Please find our review of the SSD 7919 proposal for the Loreto Kirribilli Concept Proposal and Stage 1 Development Application.

COMMENTS IN RESPONSE TO STATE SIGNIFICANT DEVELOPMENT APPLICATION SSD 7919 LORETO KIRRIBILLI CONCEPT PLAN AND STAGE 1 DEVELOPMENT APPROVAL.

The Department of Planning has asked the Government Architect NSW to provide independent design review commentary on State Significant Development application SSD 7919 Loreto Kirribilli Concept Proposal and Stage 1 Development Approval.

title
**Proposed Plans
Masterplan Proposed Plan - LG4 LG3**

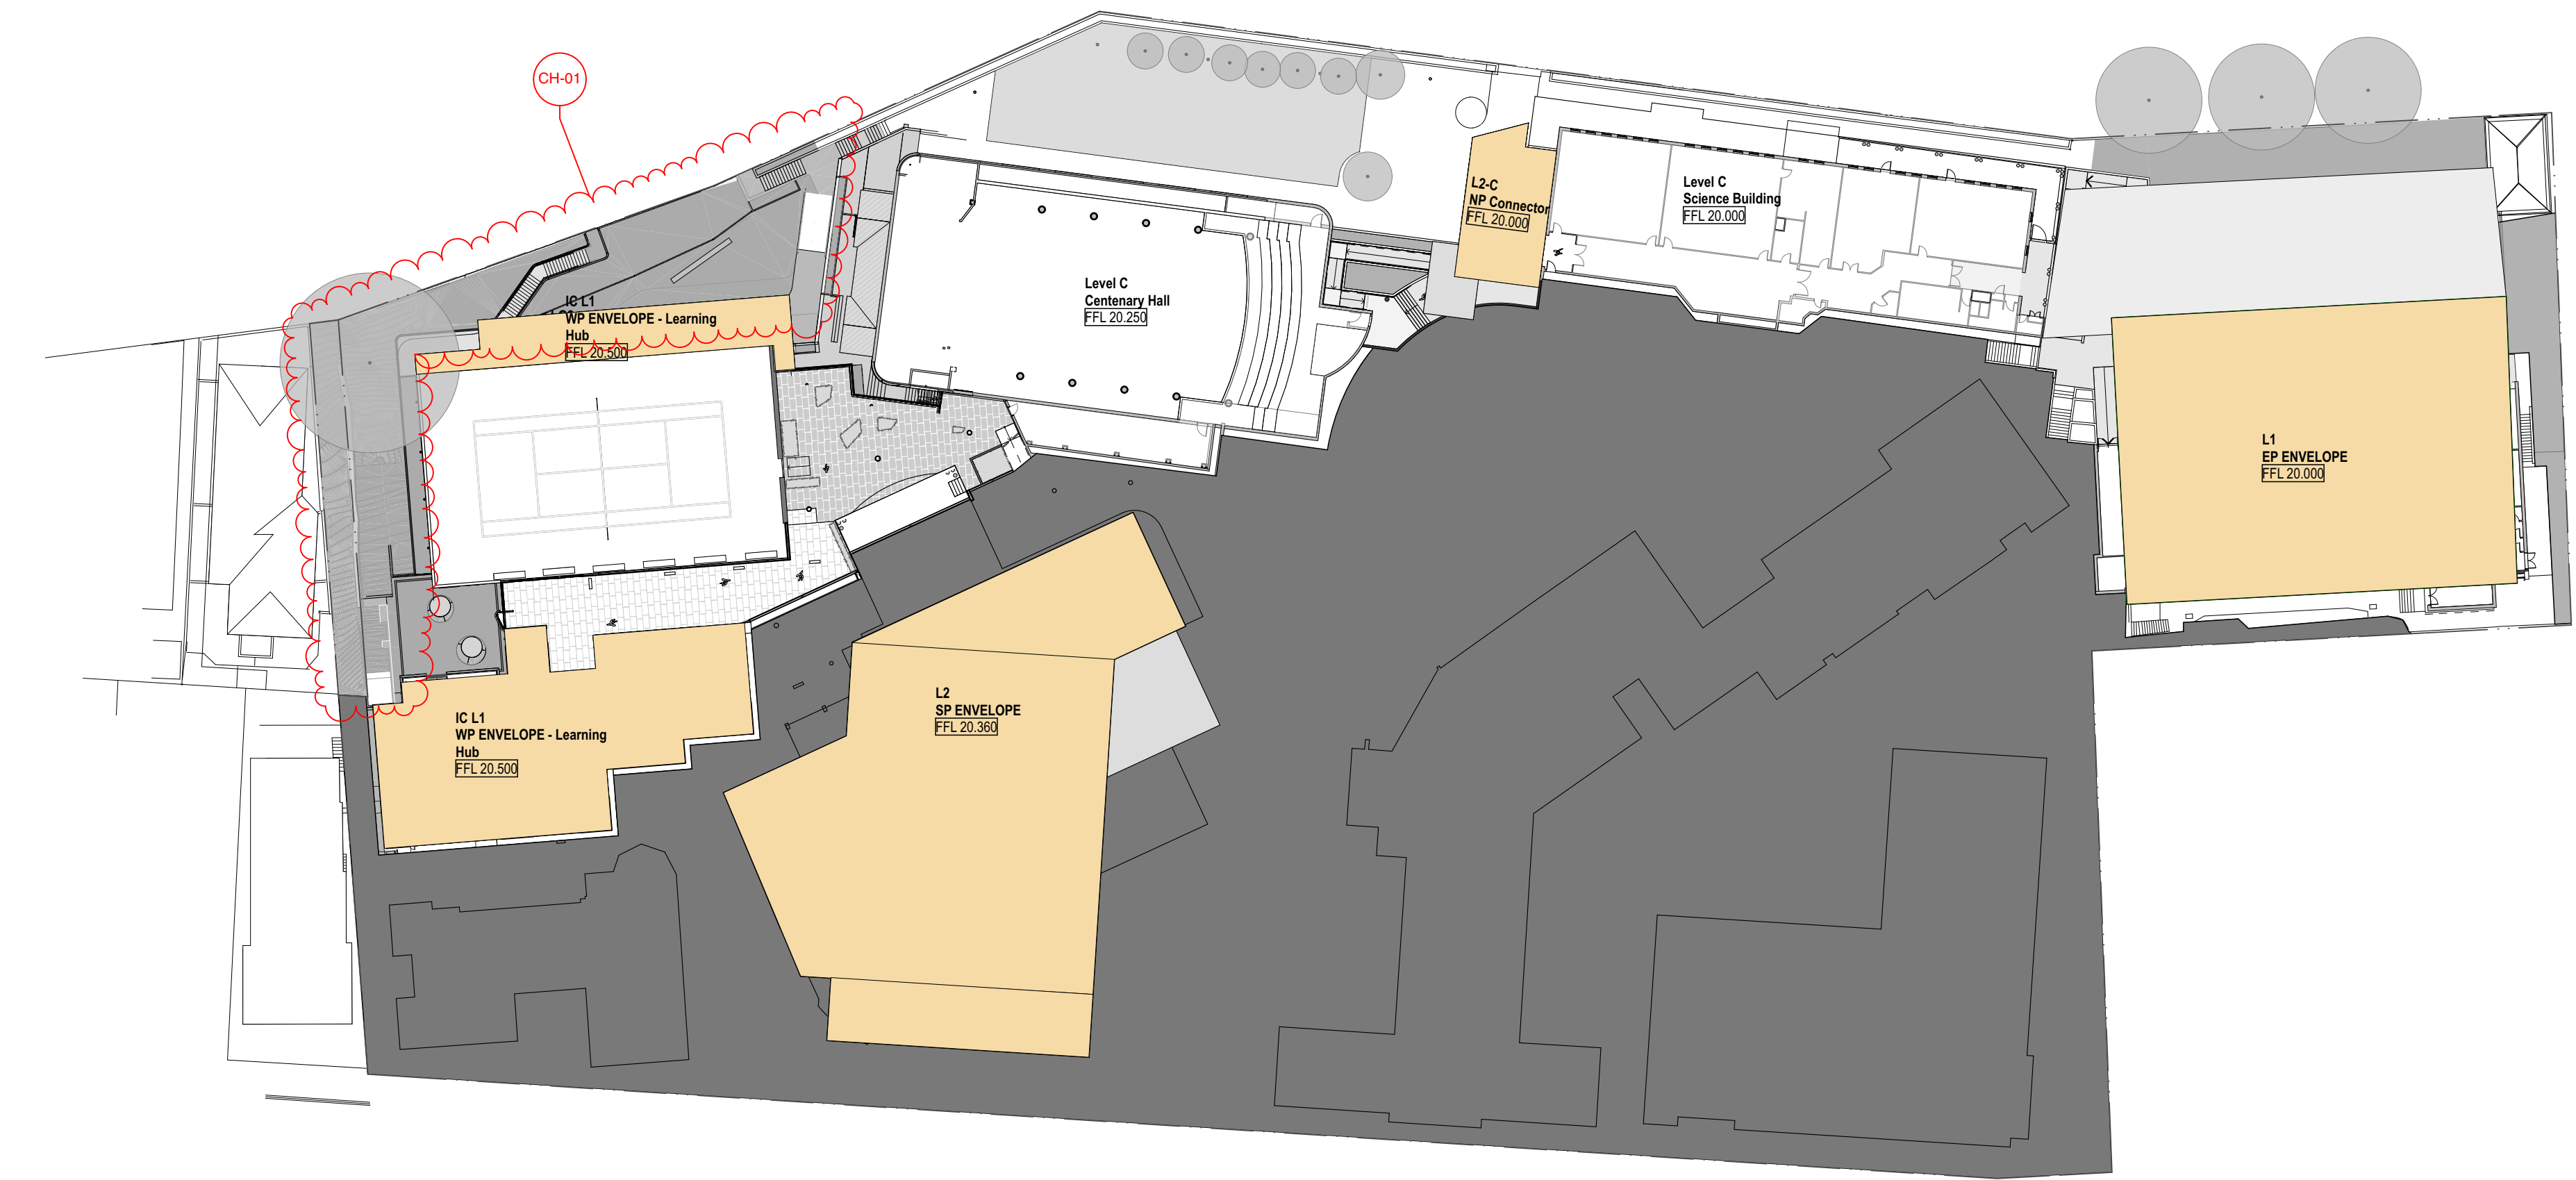
- Satisfactorily provide natural light and air to all learning spaces including the PDHPE classrooms in Lower Ground 3 and 4 of the Learning Hub.
- Address potential privacy issues from the accessible roof spaces to the adjacent apartments.

Concept Proposal Envelope Elevation

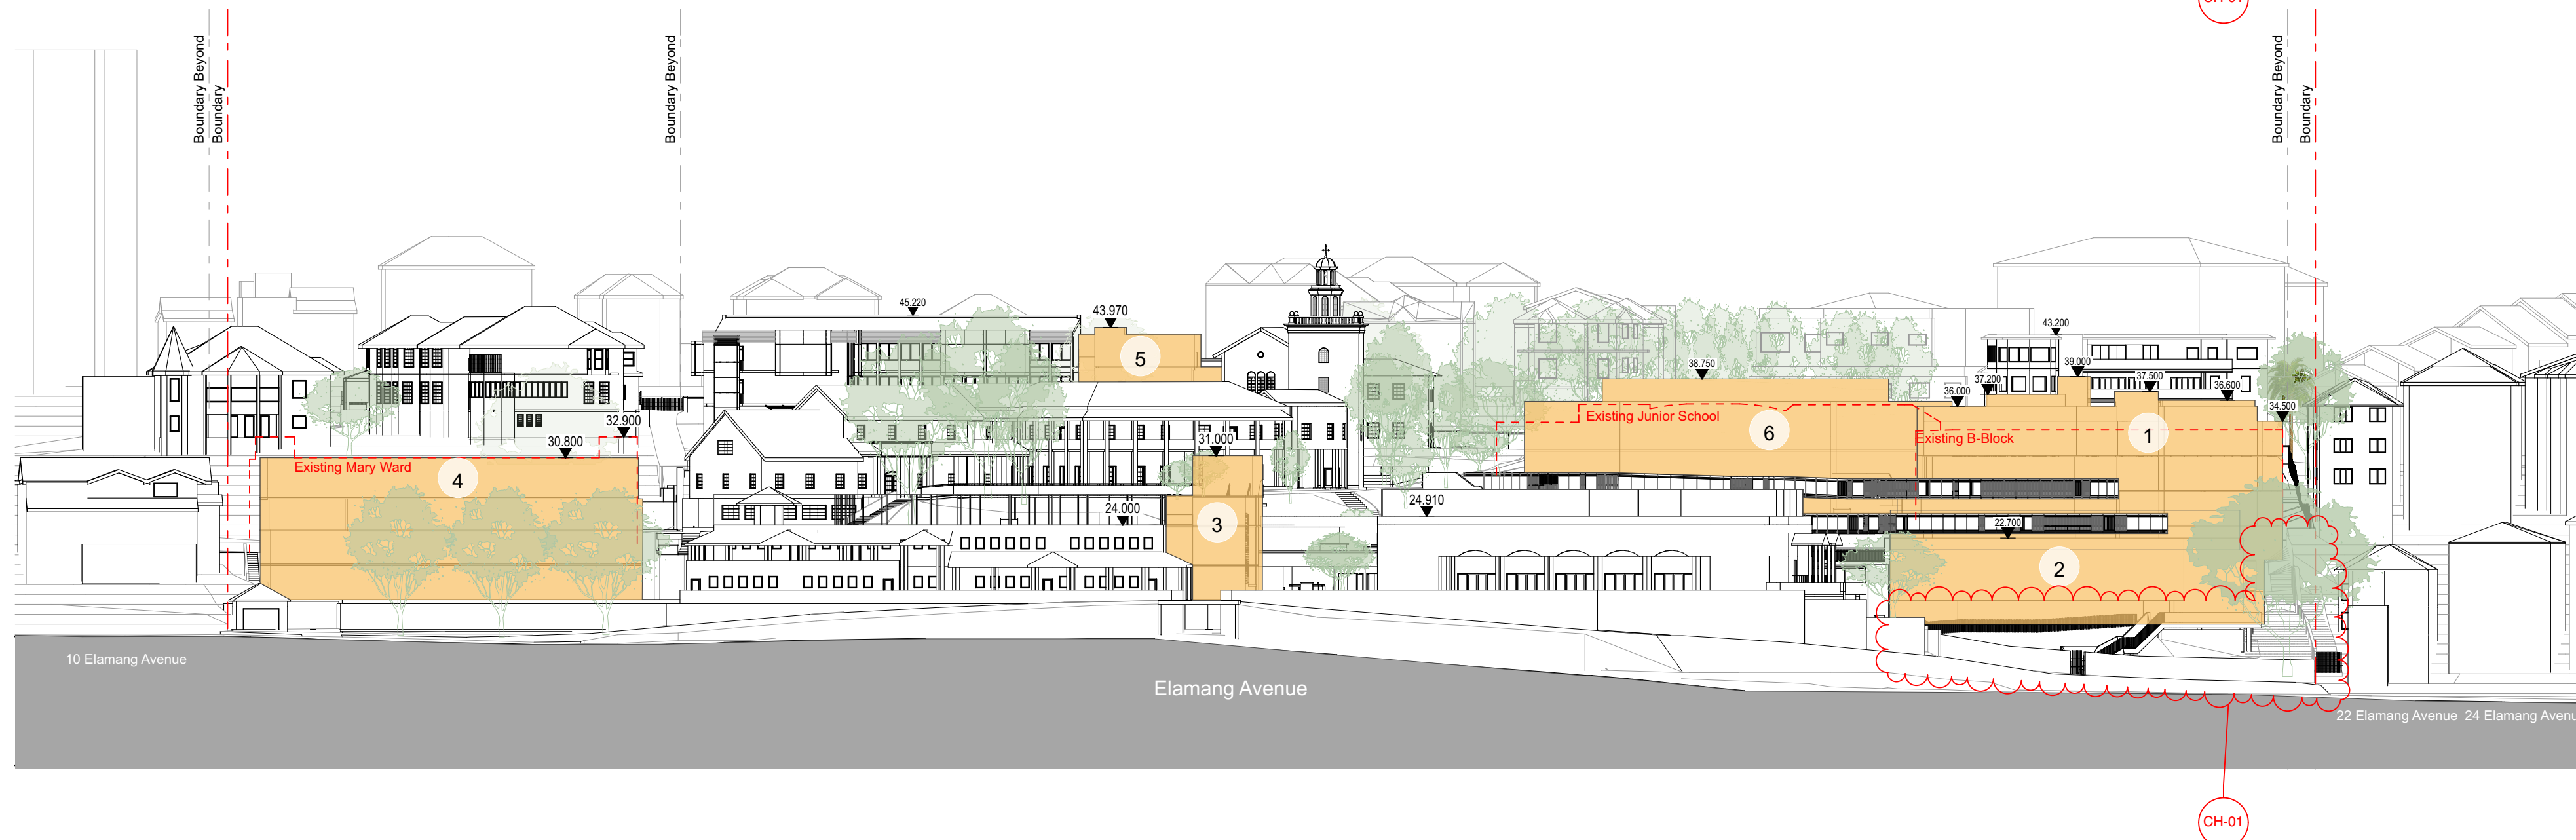
The Stage 1 proposal includes one significant new building which requires the demolition of existing buildings and the removal of a grade A (highly significant) tree. The proposal is over the maximum height and significantly impacts the views, light and amenity of a number of adjacent apartments. This impact is deemed unacceptable and the height is not supported for the Learning Hub building.

The height exceedance of the northern precinct connector building is acceptable to the minimal impact on surrounding views and amenity.
